From: ALBERT MARINER [REDACTED]
Sent: 09 April 2018 21:01
To: Planning
Subject: Planning app A/36/18 - Land at Arundel Road, Angmering

With reference to this application, I have to object on the grounds of road safety. There are a number of issues which are inadequately addressed within the supporting Transport Assessment. Aside from the unfortunate transposition which has resulted in the majority of that document (and most of its supporting data interpretation) referring to the A259 as the A529; the trip generation model chosen to assess the traffic generated by this development, is we are told (TA 6.7.1), based upon that used in local planning application A/22/12. Given that application A/22/12 relates to a single dwelling accessed by a private drive on a private estate and has no such Transport Assessment associated with it, we are unable to determine the suitability or otherwise of the model cited. Additionally, this does not give confidence in the level of peer review of the submitted report, which is heavily dependant upon the interpretation of large amounts of data and one must wonder what other numerical inconsistencies may be present and their effect on the whole.

Figure 5.4: Proposed main vehicular access point off Arundel Road.

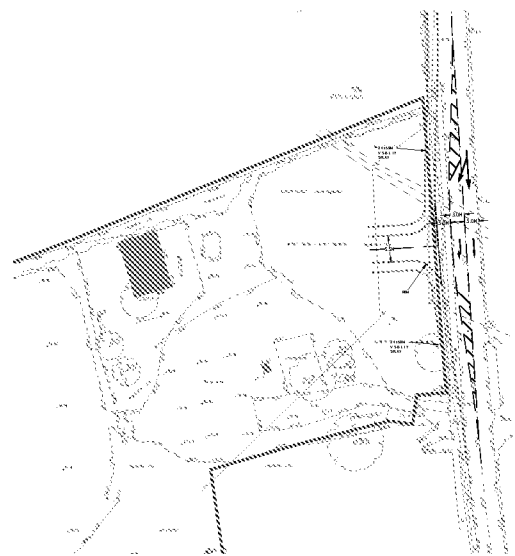
The proposed development is to be accessed via 2 separate junctions within Arundel Road, the primary point being the northernmost. This is within a national speed limit section (60 mph). The supplied traffic data suggests an 85th percentile average speed for the whole surveyed period of 37.6 mph, with an associated safe stopping distance (SSD) of 59.61 metres. The report correctly states this visibility is afforded by their design (or within 0.6 metre to be accurate). However, this visibility is only adequate for vehicles travelling at or below 37.6 mph. The supplied data clearly records an average 27% of remaining northbound traffic (between 8 am & 9 am) to be travelling in excess of this speed - on average 46 mph and in some cases up to 55 mph. As the Safety Auditors acknowledge, this is a 60 mph limit and vehicles can lawfully travel up to that speed (thankfully, very few do and this is also reflected in the supplied data. That said, numerous vehicles are recorded as having passed at up to 55 mph during the peak AM periods throughout the school week). The proposed main junction can barely meet the minimum visibility for traffic on Arundel Road and cannot provide the 79 metres visibility necessary to see the average 46 mph of the remaining 27% (1 in 4 vehicles in real terms) of traffic approaching from the south. It is sobering to consider that the SSD for 60 mph is a totally unattainable (for this location) 121.7 metres.

A further complication is that currently, at school times, vehicles park along the western road edge within Arundel Road up to (and on several recent occasions) beyond the hill crest. This is well within the visibility splay of the proposed site access and would severely compromise the already minimal 59 metres available. The height of this parking occurs when pupils are being delivered to school in the morning, precisely at the peak period for traffic exiting the development and others using Arundel Road.

Another concern has been raised by the Safety Audit team - that of the access to the site afforded to refuse vehicles. The TA report's authors appear to have misinterpreted the auditors' concern in this respect, as they only refer to the goods vehicle's intrusion into the (southbound) right turn lane from Arundel Road into the development. The Auditors' concern includes the need for the left turning goods vehicle to fully occupy the (eastbound) exit lane from the development onto Arundel Road. If the vehicle is prevented (by leaving traffic) to use this lane, it cannot enter the development until that traffic has cleared and would therefore have to remain within Arundel Road until such an opportunity arose. This would quickly lead to a build up of traffic behind it and (with the presence of parked vehicles from the school) a complete obstruction of the southbound lane, with nowhere for the majority of the site's exiting traffic to go. The design engineers appear to ignore the fact that refuse vehicles will not be the only large goods vehicles which will have to access the development throughout a normal day. Numerous deliveries by larger vehicles are commonplace nowadays with the increase of online shopping. It would seem logical to re-engineer the proposed junction's bell mouth to better facilitate such manoeuvres.
